Our R/2016/37/F
reference:

Your SSD-6966-Mod-4
reference:

Subject: Barangaroo Building R5 - SSD 6966 Mod 4 - Design and Parking Amendments -
Advice on Modification

Attachment E: Parking Layout Diagram

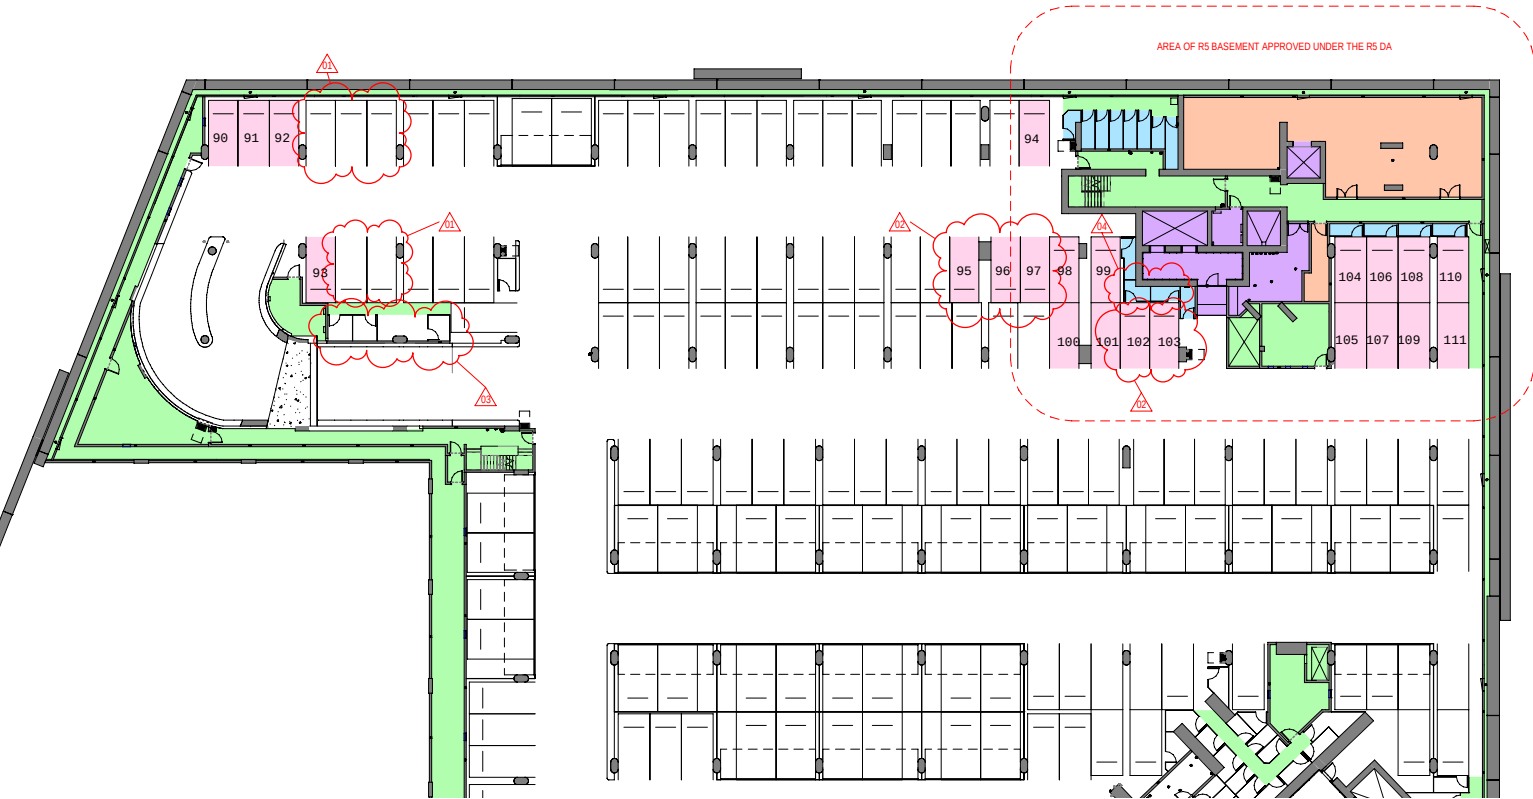
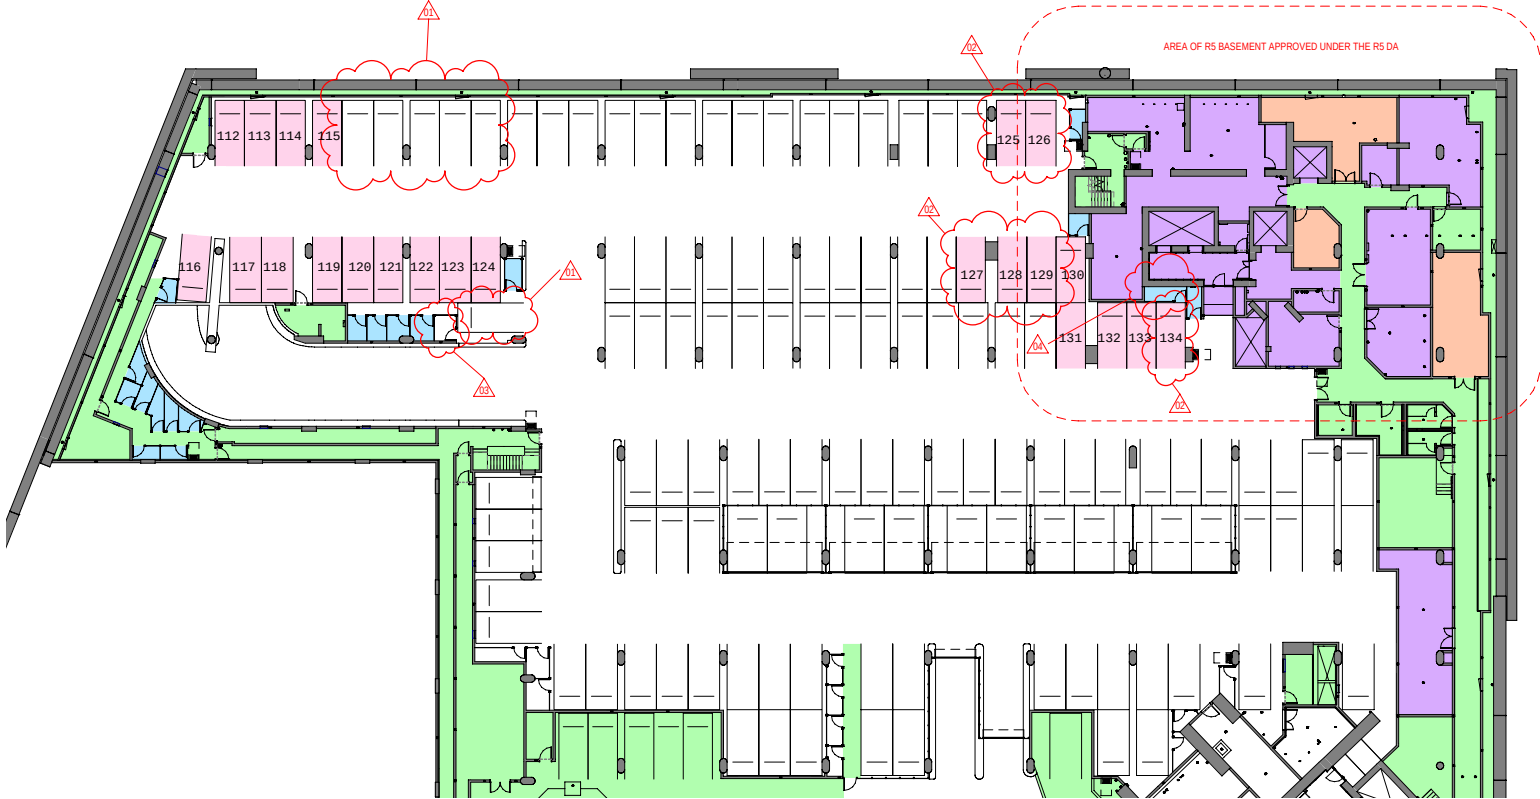
However, clarification is required regarding the proposed deletion of 9 car parking spaces dedicated to KWH. Although the Transport Statement submitted indicates that the total parking quantum is to be reduced from 143 to 134 by removing the 9 designated KWH spaces, it is not clear from the documentation (and with no modified basement plans lodged) what the area where the car parking spaces are currently located is going to be converted to.

If these 9 spaces were to be allocated as additional parking to the other on-market residential units, Council would strongly oppose this. The approved parking quantum was agreed to on a rates-basis, that is, a certain number of parking spaces per dwelling. Whilst the KWH provider may wish to reduce their parking rates, this should not give way to increased parking rates for other parts of the development.

Instead, the Proponent should consider converting the use of this area which is no longer needed for KWH car parking, to provide for increased storage or amenities for the KWH, or perhaps car share spaces or EV charging locations to support the overall development.
